SPR EA1N and EA2 PROJECTS

DEADLINE 8 – COMMENTS ON OUTLINE CODE OF CONSTRUCTION PRACTICE SUBMITTED AT DEADLINE 7

Interested Party: SASES PINS Refs: 20024106 & 20024110

Date: 25 March 2021

Figure 1 Potential Sensitive Receptors and Areas Subject to Additional Construction Phase Controls

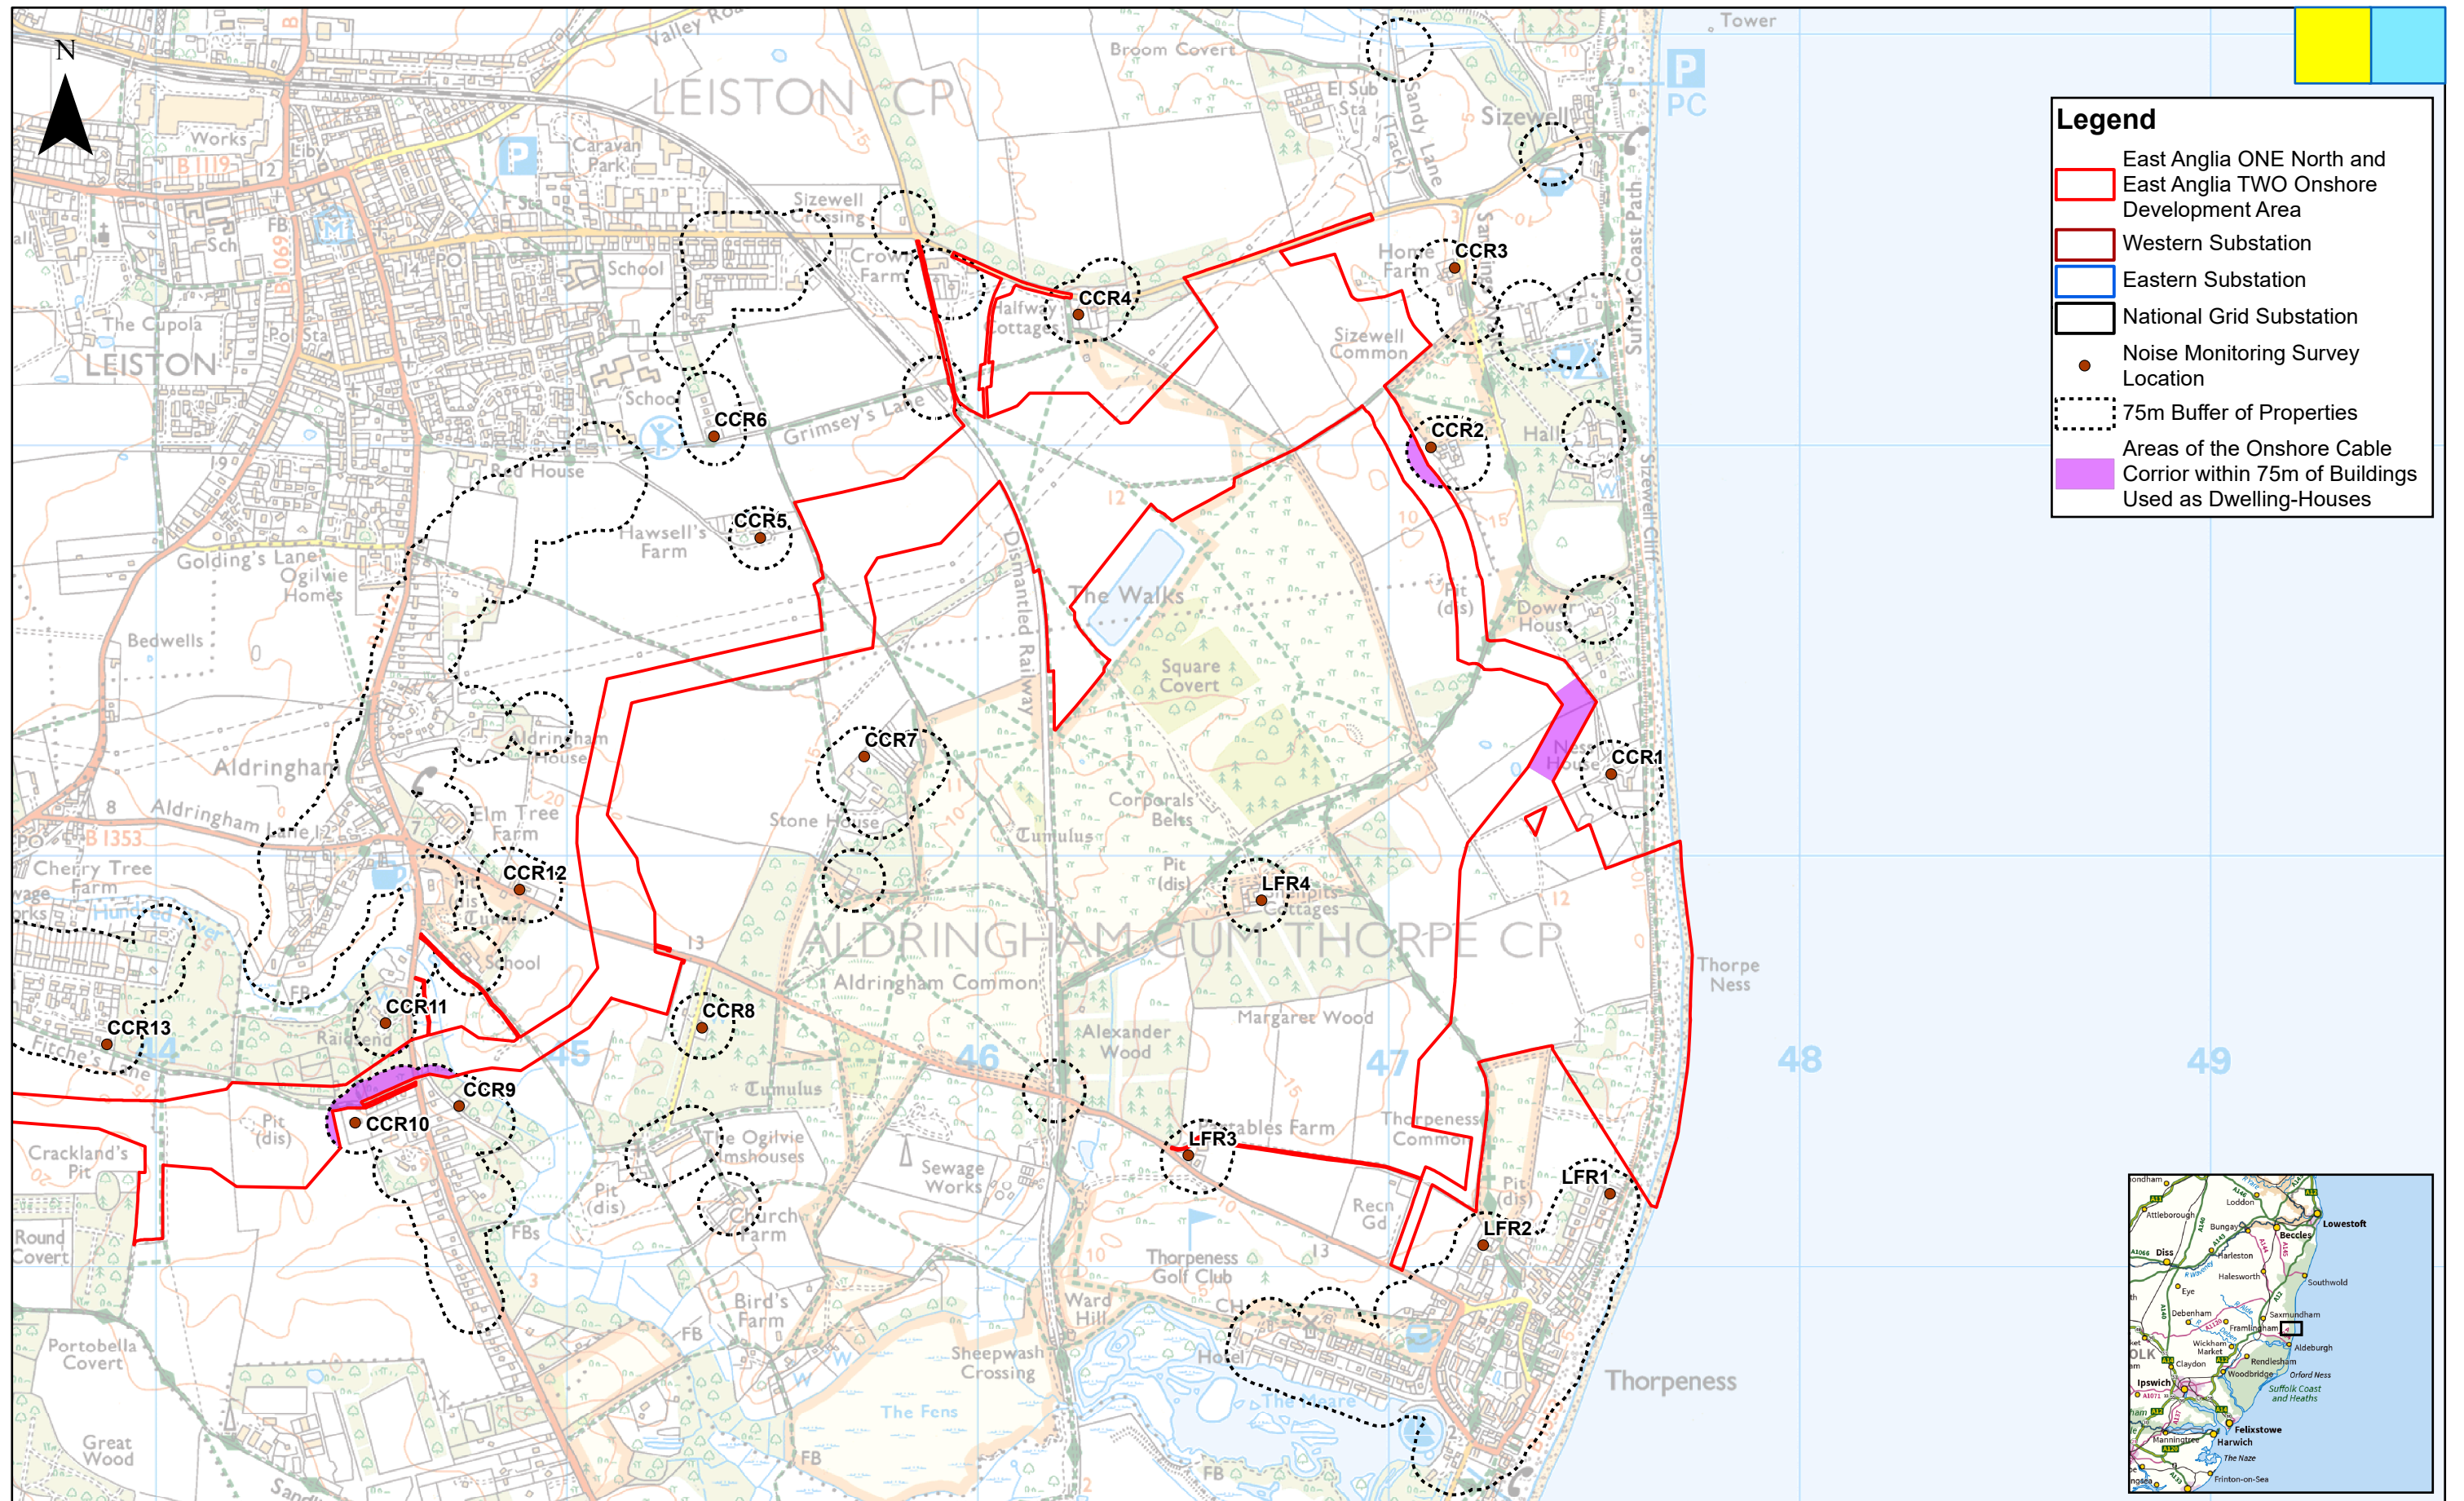
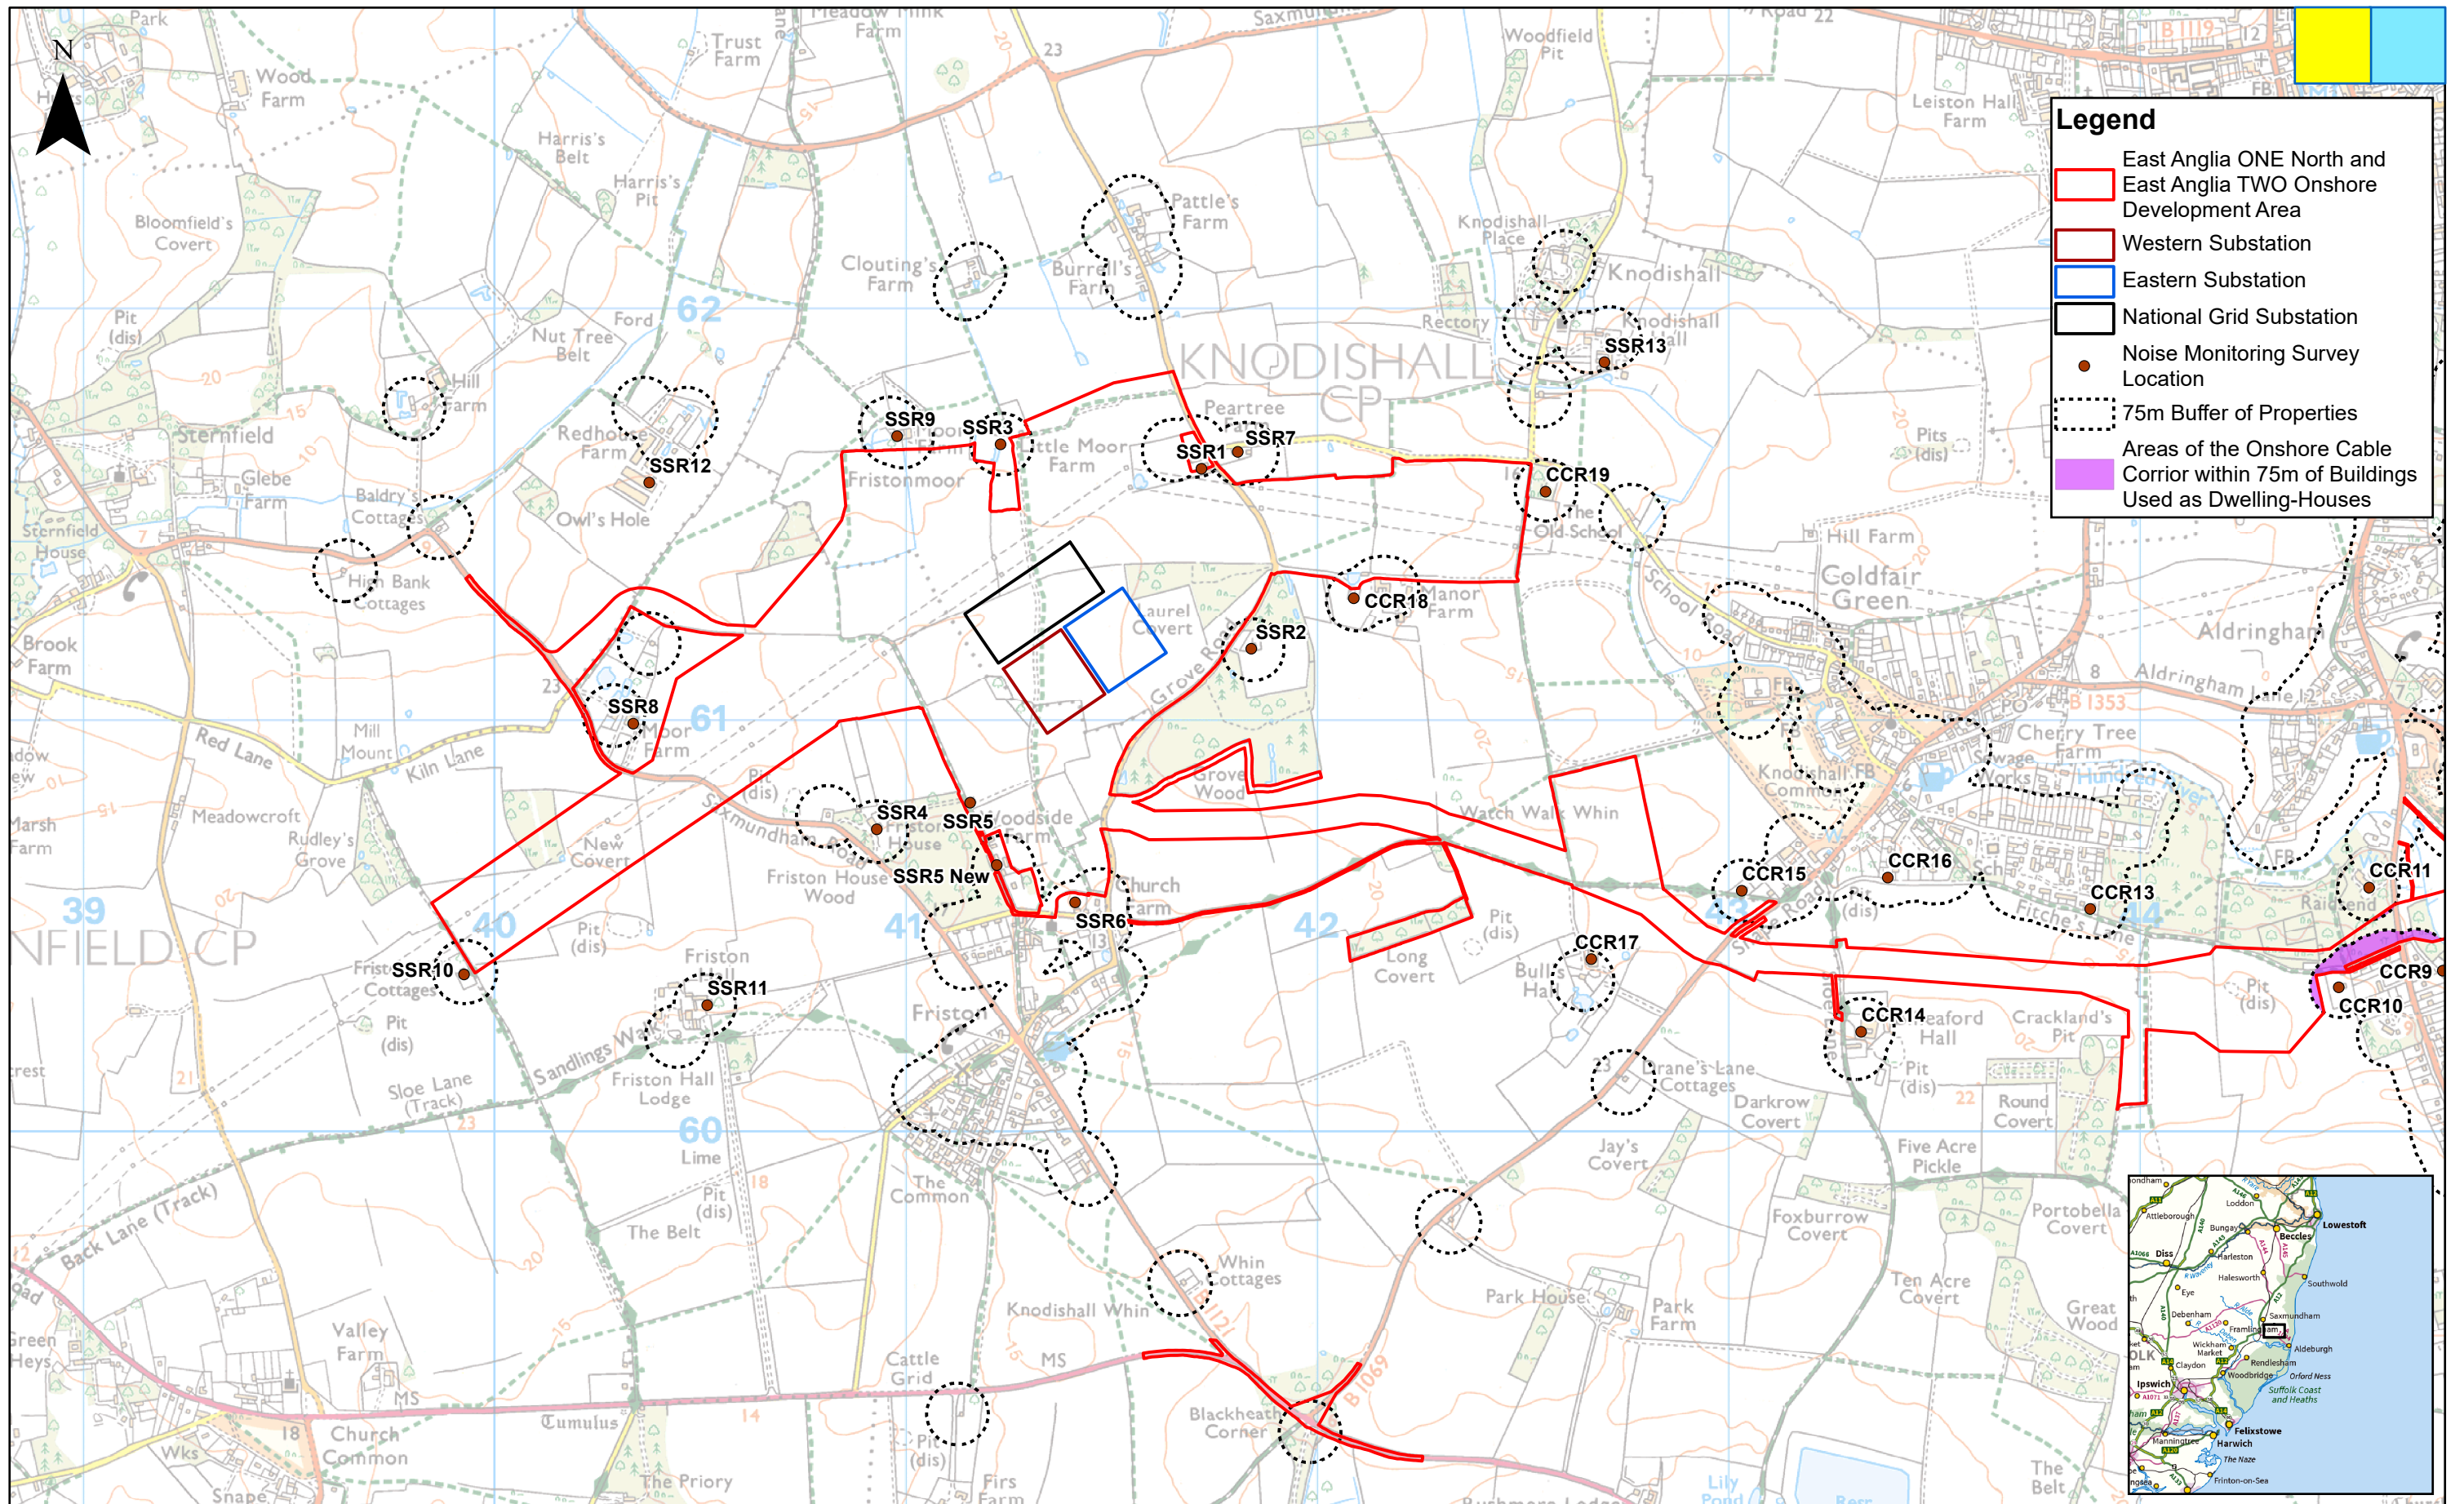
9. **Paragraph 107** - The ExA asked those attending ISH12 whether there are any particularly sensitive receptors near the Hundred River (other than those in Fitches Lane) that require particular monitoring measures. The property Riverwood in Gypsy Lane is particularly vulnerable owing to its close proximity to cable corridor activities on its east side and the Hundred River Watercourse crossing on its north side. Prior to the 2018 EIA it was decided that CCR9 would be located on the west side of the property. Possibly at that early stage the high volume of HGV traffic forecast to be travelling along the B1122 towards landfall site was perceived to be a major source of noise disturbance. The Traffic Management Plans were revised prior to DCO submission and the main source of construction noise at Gypsy Lane would be to the east and north. We propose the following sentence is appended to 9.1.2 Onshore Cable Route Construction Noise Control, paragraph 107.

“A priority review of the location of Cable Corridor receptor CCR9 in Gypsy Lane to be undertaken with a view to its being located for monitoring purposes on the north-east side of that house. In its present position it is shielded from the major sources of anticipated construction noise by the house itself.”
